Please treat as a substitute plan and amend description

Please find attached an updated Location and Block plan drawing no. 181303/10A, which I would kindly ask you to substitute with the current Location and Block Plan drawing no.181303/10. I would ask that the proposed garage building be omitted from the current application proposals, as we will submit a revised design as a new application in line with your advice.

ring
field
d
House
-
R23
0/1
9/P
L

Job Title	Springfield House		
Client	Castle Property Developments		
Drawing Name	First Floor Plan		
Drawing Status	Planning		
Drawn by	DF	Date	July 18
Checked by		Date	
Drawing Scale	1:50 at A1		
Drawing No	Status	Revision	
181303/ 02		A

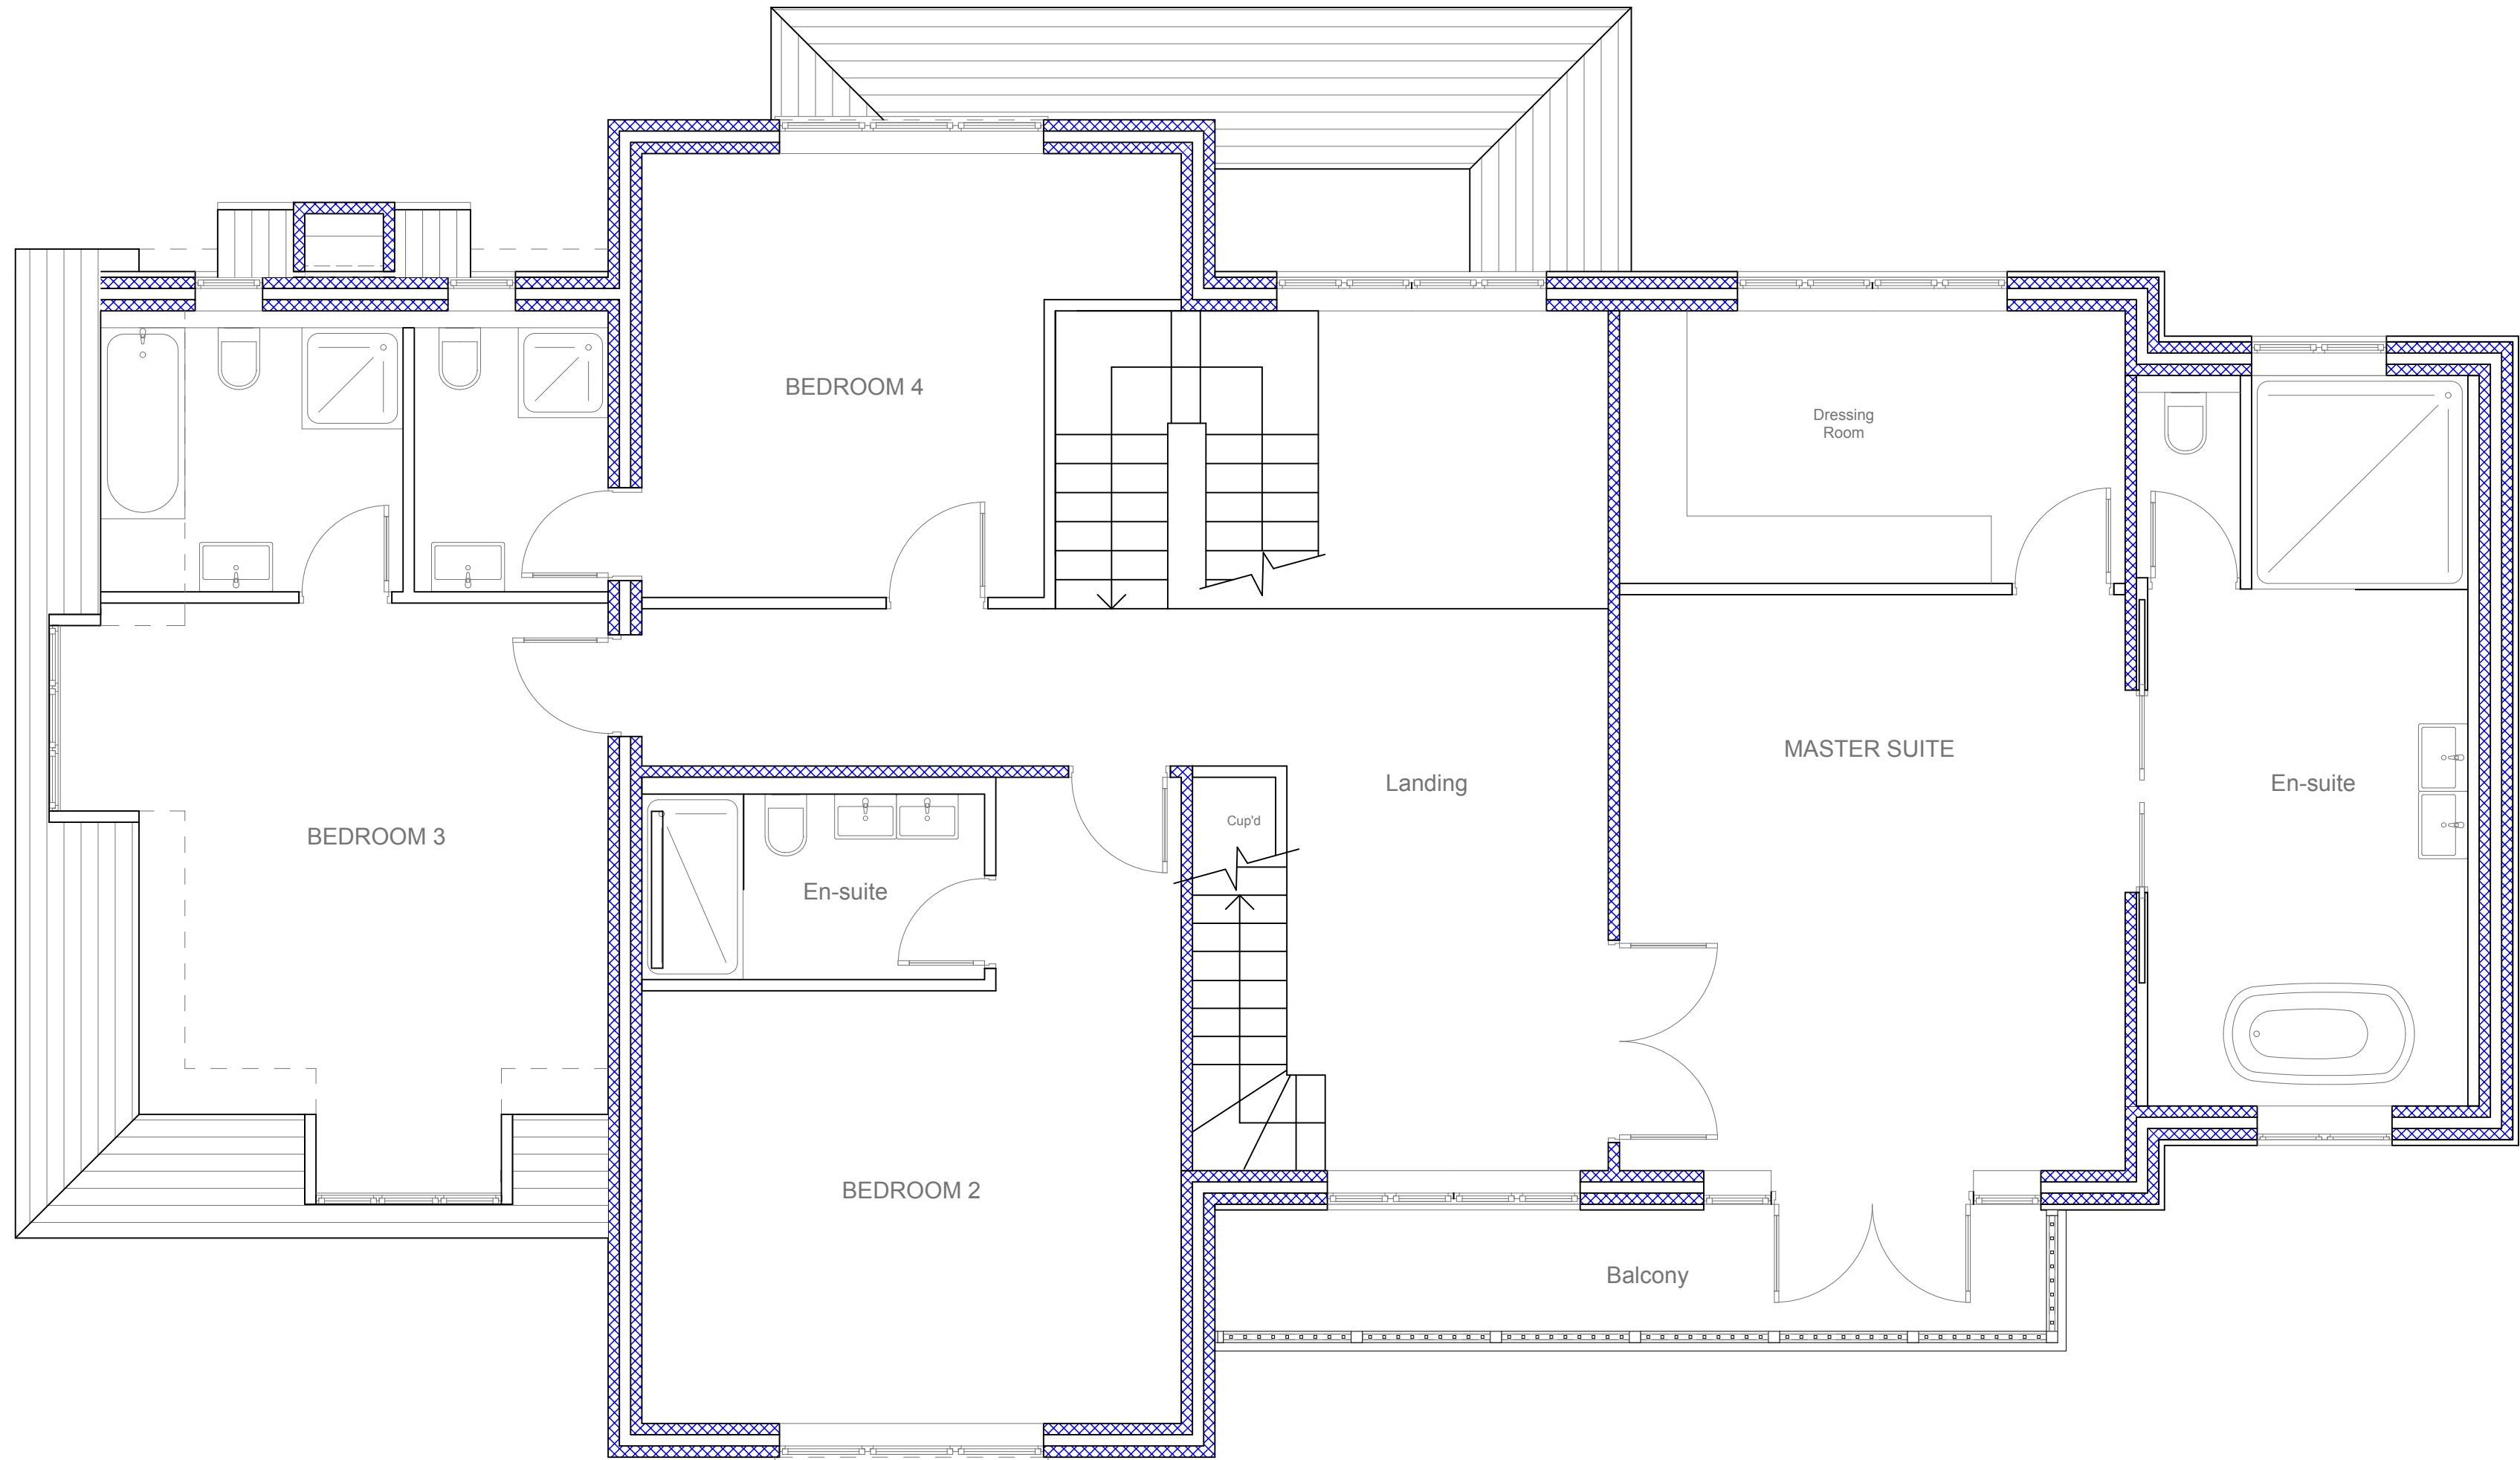
I can confirm that the East side of the proposed balcony is 10.1m from the boundary. Please could you confirm that this is acceptable in terms of overlooking, and the balcony would therefore not require a privacy screen.

Job Title	Springfield House		
Client	Castle Property Developments		
Drawing Name	Garage - Plan & Elevations		
Drawing Status	Planning		
Drawn by	DF	Date	Sept 19
Checked by		Date	
Drawing Scale	1:50 & 1:100 at A1		
Drawing No	Status	Revision	
181303/	09

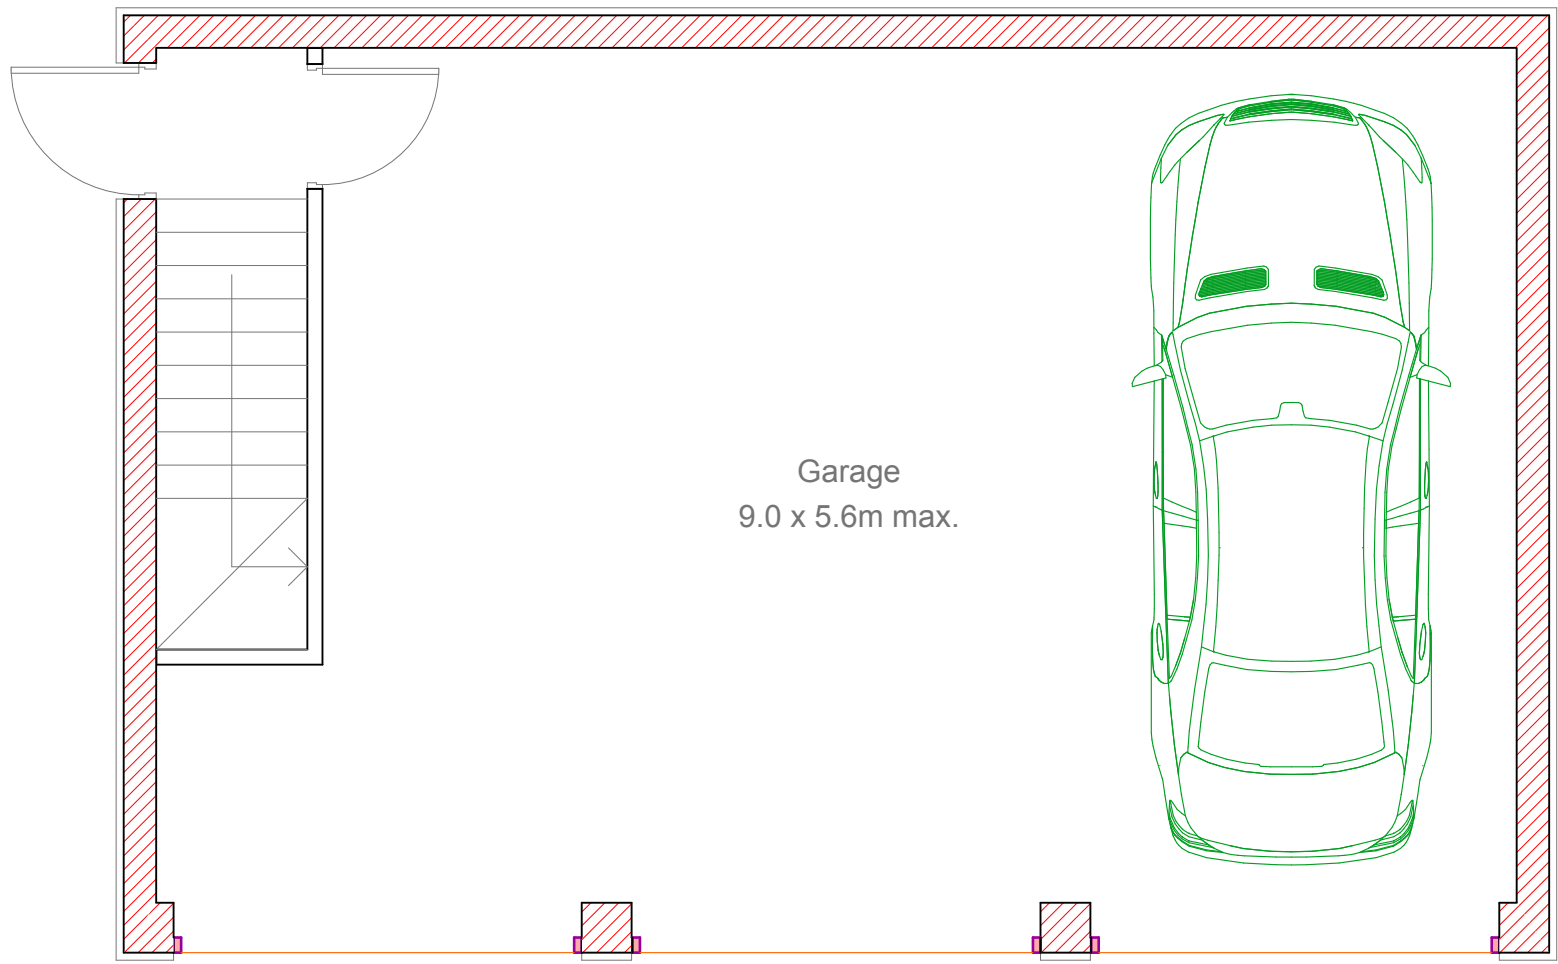
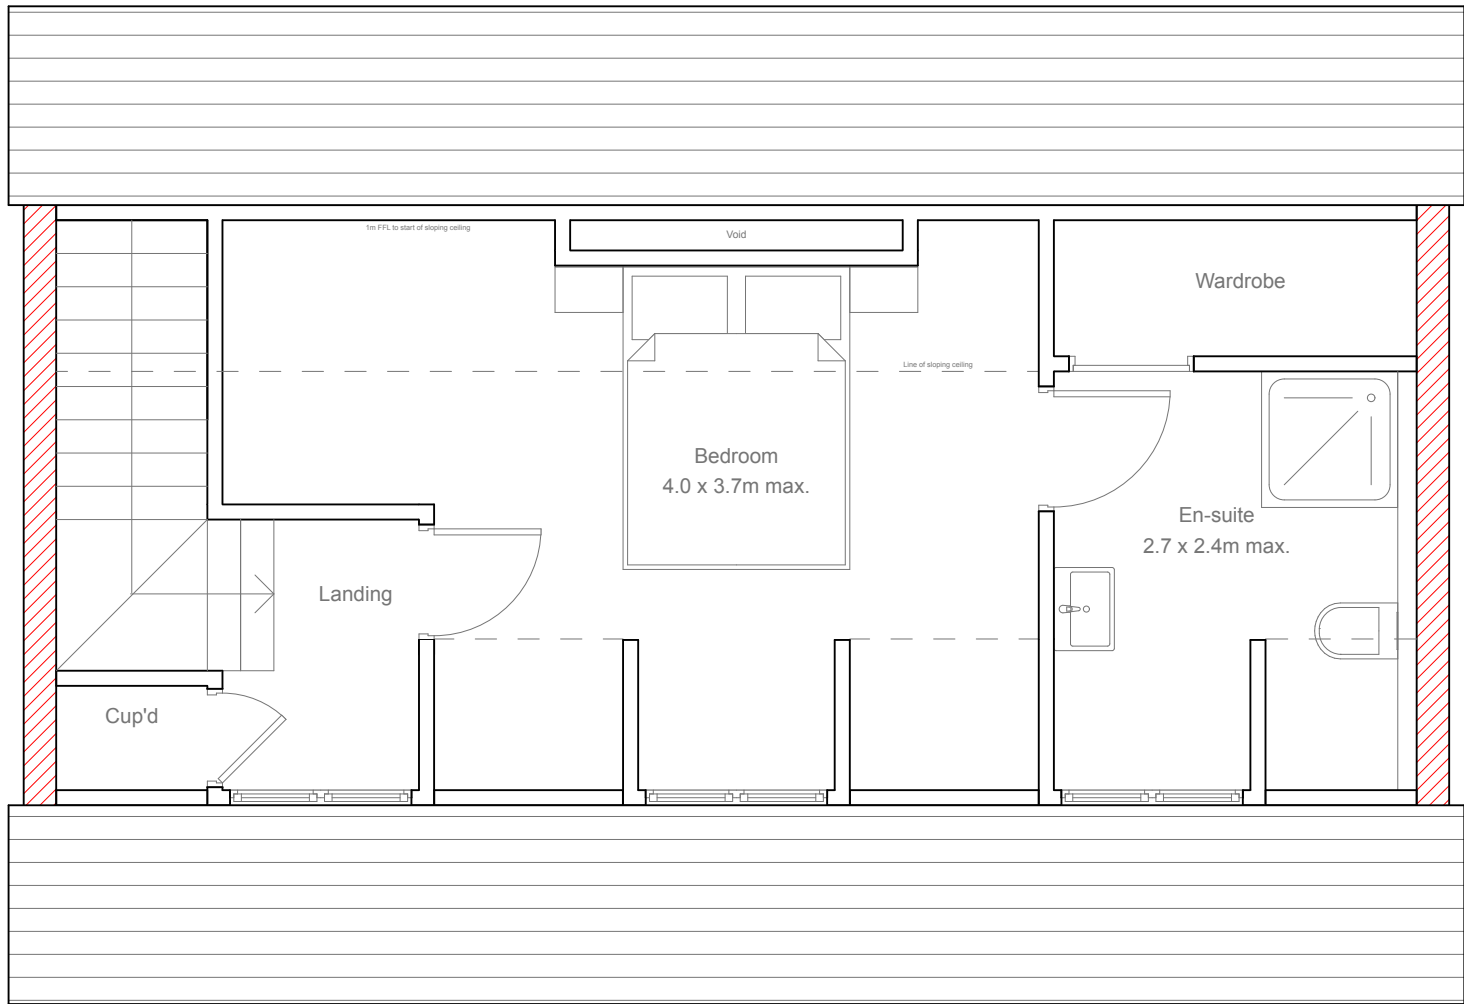
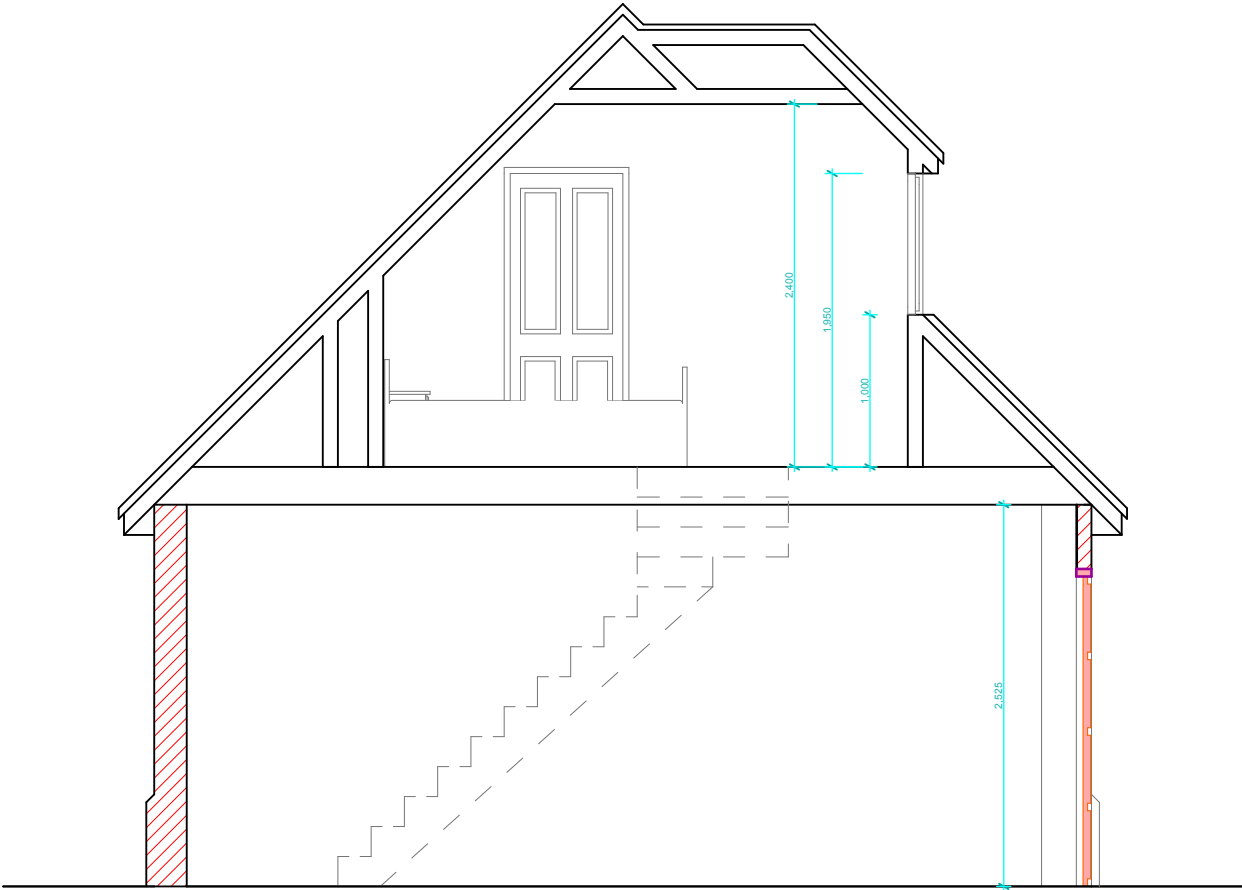
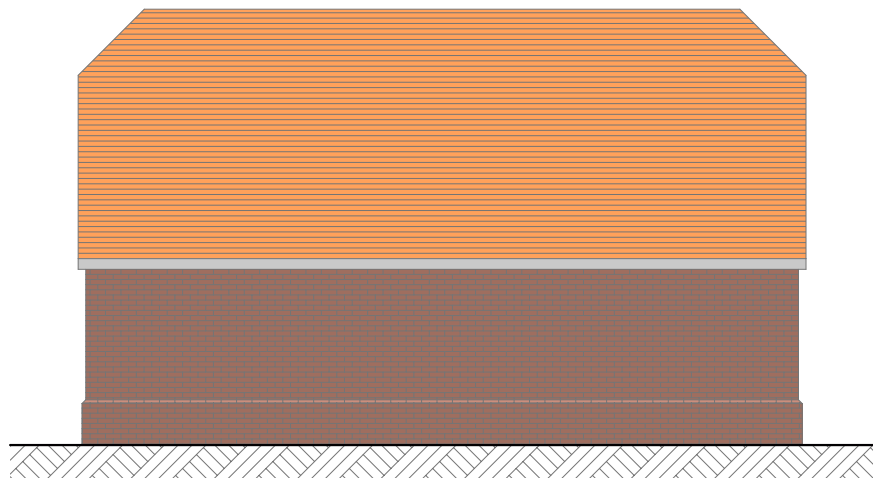
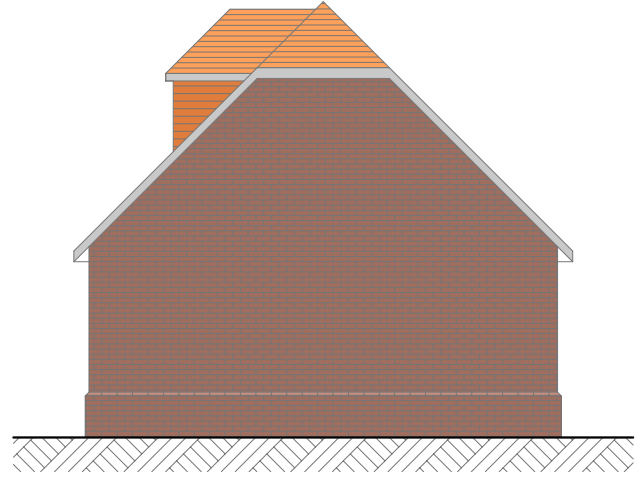
I have checked and can advise that in order for the application to continue to a positive recommendation the garage should be deleted from the proposal. We will not accept amended design and siting as part of this application.

Is there any way I can substitute the existing Garage design with a revised design (lower roof, omit dormers and move further away from the boundary) to include within the scope of this application, albeit that I realise you will need to re-advertise, or would it be preferable to remove the Garage and resubmit separately to enable you to approve the pool, balcony and skylights before Christmas?

Title			Proposed New Foul Drainage		
Scale	1:500	At original	A4	© Robert Clark Associates Ltd	
Drawing Number	1772/F/SK2		Revision		-

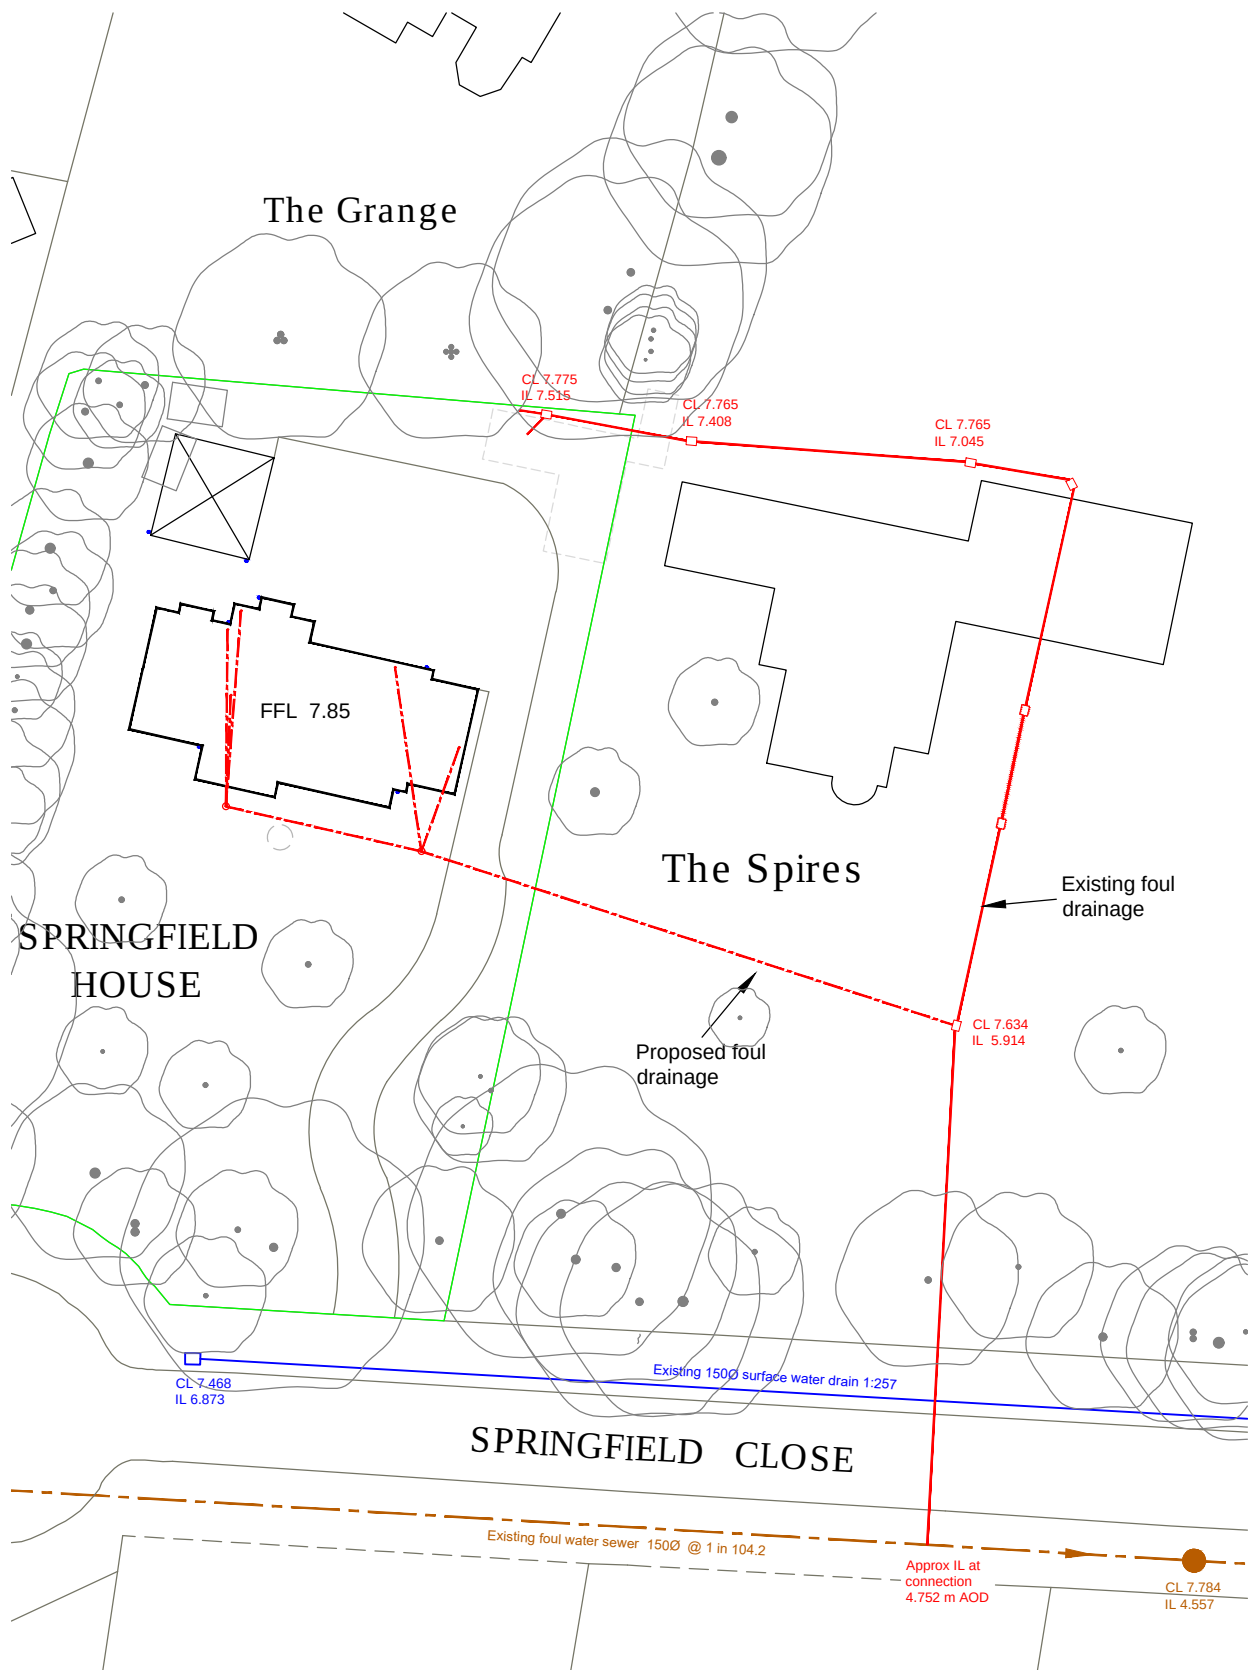
t is
ass
um
ed
tha
t
the
poo
l is
ope
n
and
not
cov
ere
d. If
it is
cov
ere
d
the
n it
will
nee
d
to
be
acc
oun
ted
for
in
the
Sur
fac
e
Wa
ter
Dra
ina
ge
Des
ign.
Thi
s
has
not
bee
n
con
fir
me
d.
No
info
rm

ation is given for how the pool will overflow and backwash. It is assumed that this will go to the foul sewer but this is not shown on the Fouling Drainage Drawing. Southern Water will need

d
to
be
con
sult
ed
if
this
is
the
cas
e.
The
foul
dra
win
g
als
o
sho
ws
the
for
mal
ly
app
rov
ed
2
bay
gar
age
whi
ch
this
app
lica
tio
n
re
mo
ves.
The
pro
pos
ed
3
bay
gar
age
is
not
sho
wn.

Please find
attached a revised
foul drainage
drawing as
requested.
